City of Albuquerque Stormwater Construction Site Inspection Report

ESC File No.	M10E020	Project Name:	Kidz Academy and The Human Bean		
NPDES Id. No.	NMR1003NO/NMR1003NP	Location:	7800 Sage Rd. SW		
1/26/2022	Owner	Contractor			
Operator	Kidz Academy and Tres Lobos	Creative Design Builders			
Contact name & title	Keith Griego	Raymond Herrera			
e-mail	kidzacademystaff@gmail.com	rhcdb46@yahoo.com			
Contact Phone #	505-681-7812	505-410-9020			
COA Inspector	Doug Hughes	Start/End Time:	4pm		
Construction Phase:	Vertical				
Type of Inspection:	Regular	Storm Event	Past Storm Event >0.25"	311/Complaint	Follow Up
Weather at time of inspection?		clear		Temperature: ~	40
Estimated date of last storm 0.25" or greater		1/1/2022

TEMPORARY EROSION AND SEDIMENT CONTROL PLAN

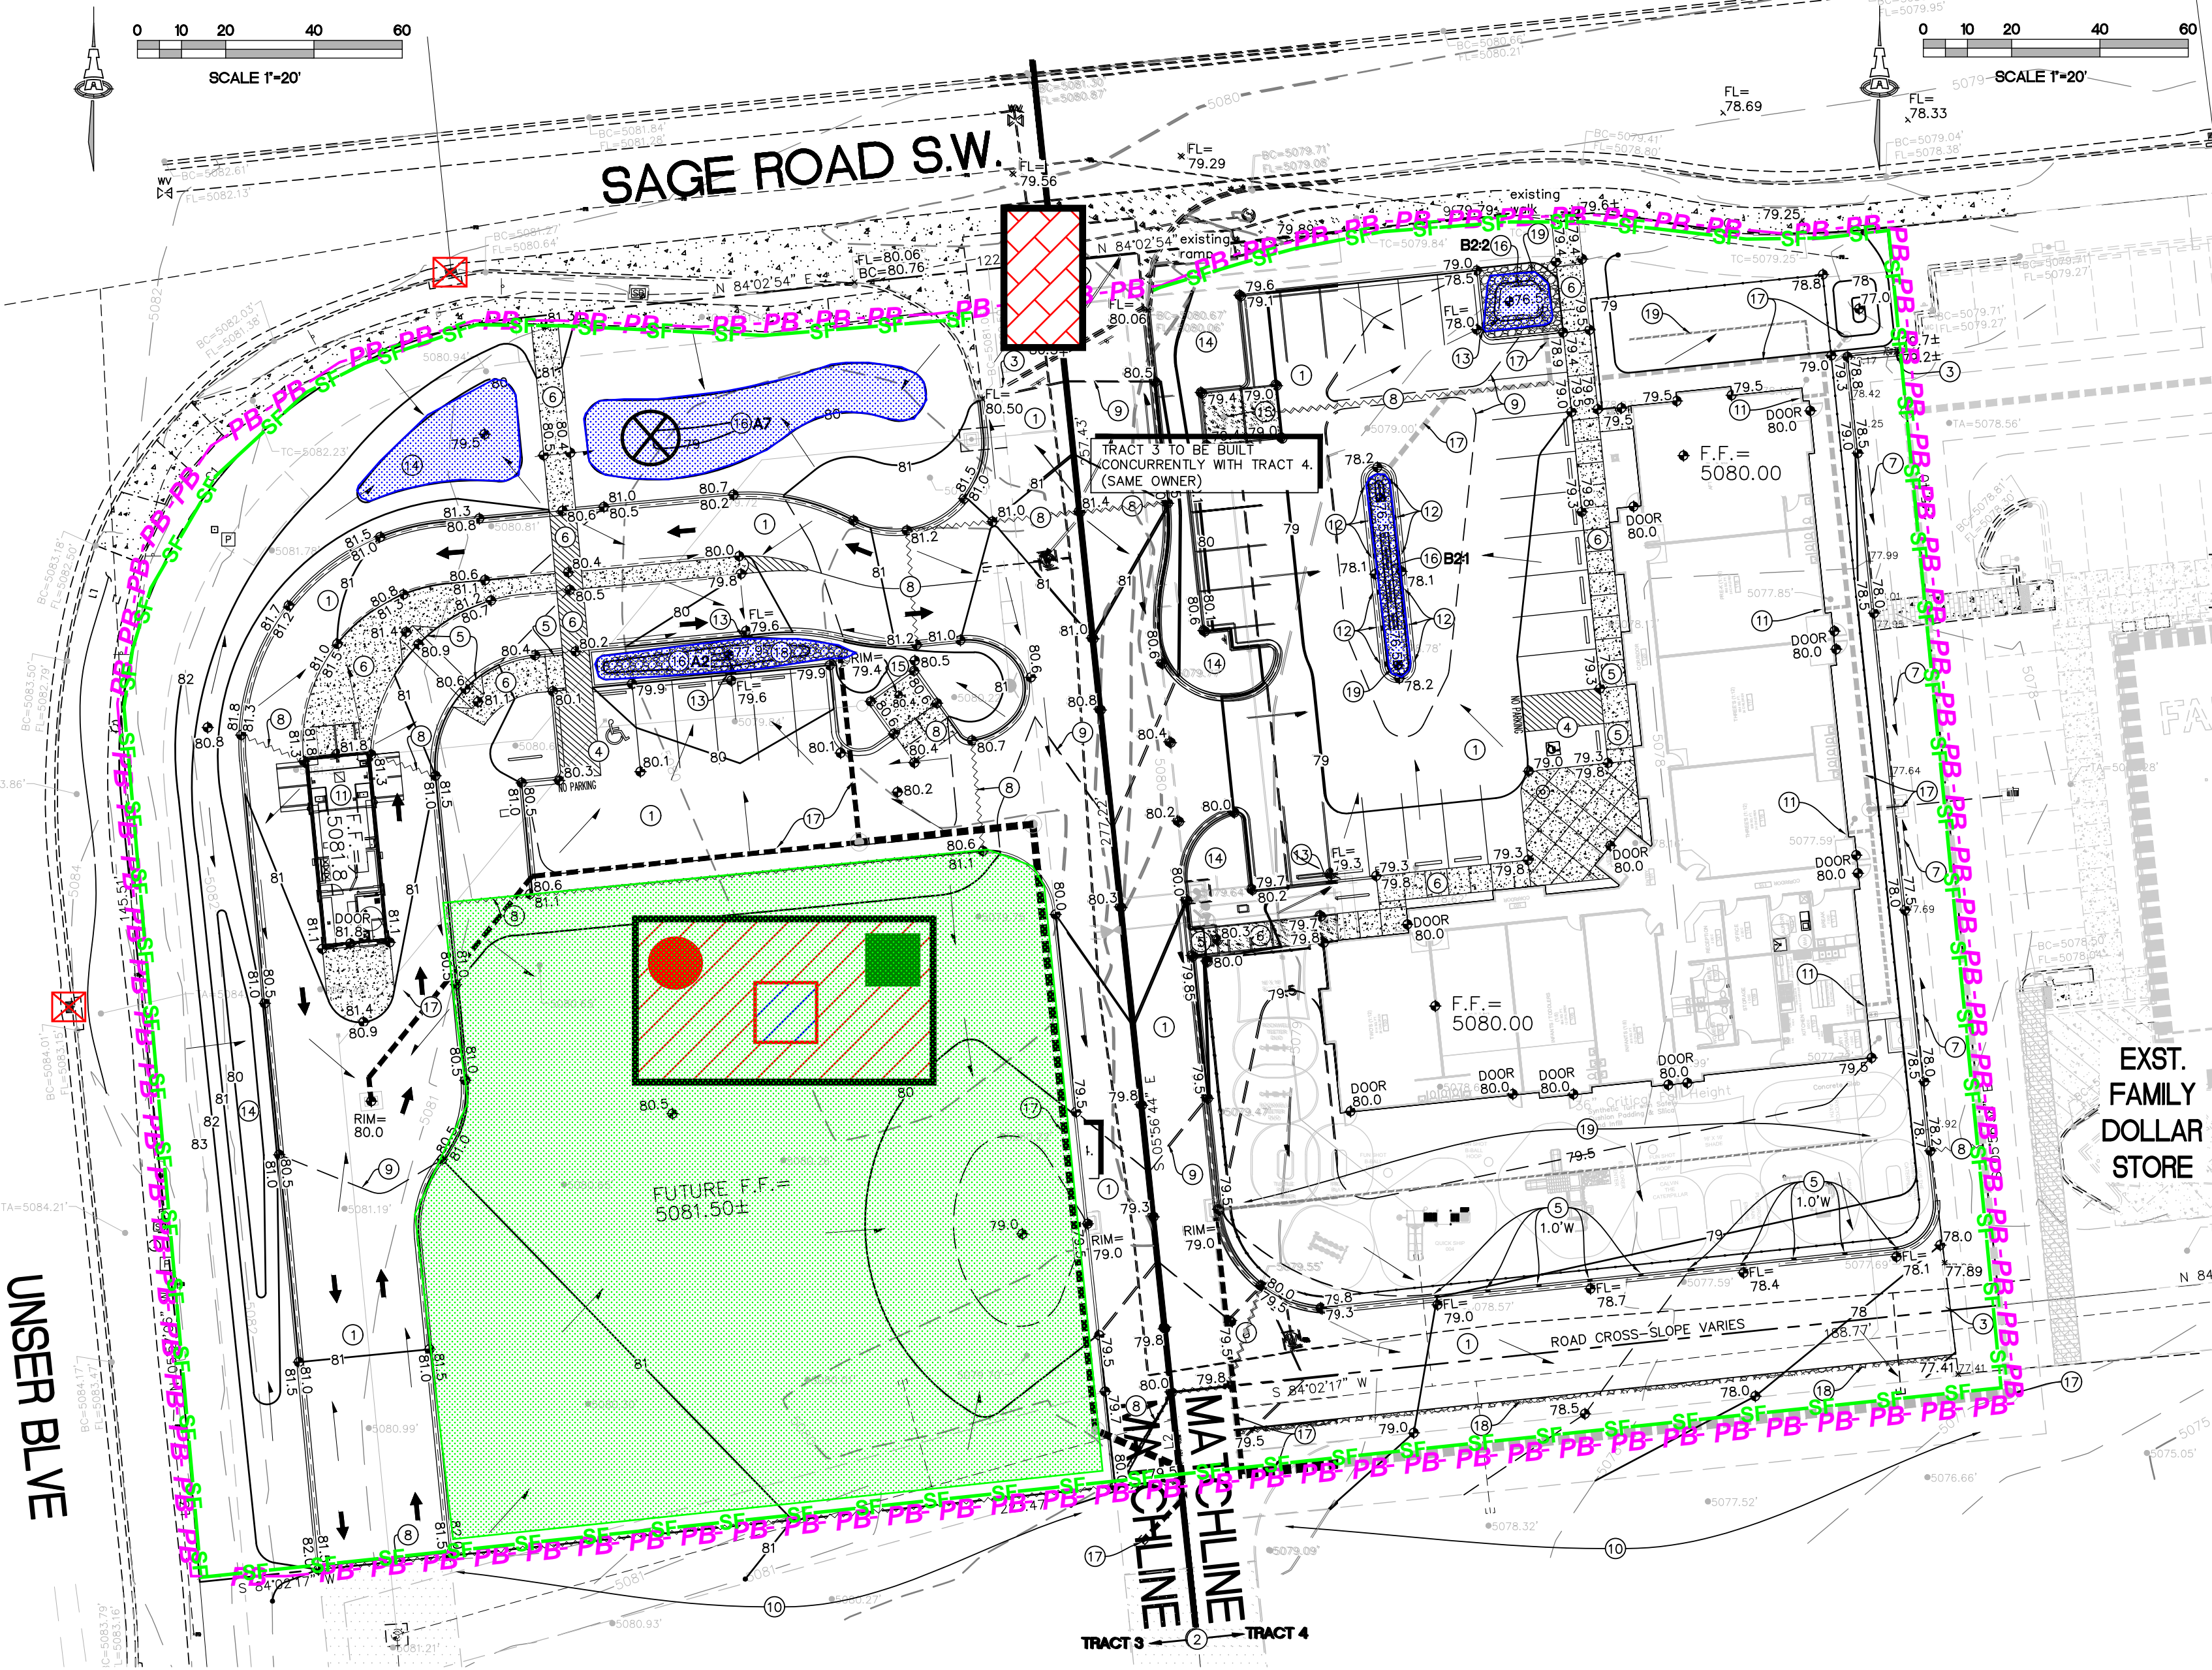
Item Number	Deficiency/ Corrective Action				
1	Inlet Protection in Sage downstream of the site is not maintained and and there is too much sediment in the street upstream of the inlet. Sediment must be removed from Sage and from the parking lot east of Kidz Academy and the inlet protection reset.				
2	Silt fence is missing. The areas of disturbance south of the site, both onsite and on the adjacent property must either have silt fence or final stabilization, and the debris removed in a covered waste container.				
3	The SWPPP wasn't available and its location wasn't identified on the sign because the sign was missing. Last inspection - 1) Reports were not signed by Operators or Delegated Authority 2)swq team not per CGP 6.1. The SWPPP mis be u-to-date including the map, and be accessable onsite, its location posted.				
4	Posting of NPDES Permit coverage was missing and must be posted for safe public viewing for all three operators.

Human bean looked like it is open for business but signs missing, Kidz academy is nearly complete. Incomplete stabilization, lack of posting, sediment, and missing BMPs must be mitigated. Raymond said he couldn't get it all done by Monday so an extra week is being allowed.
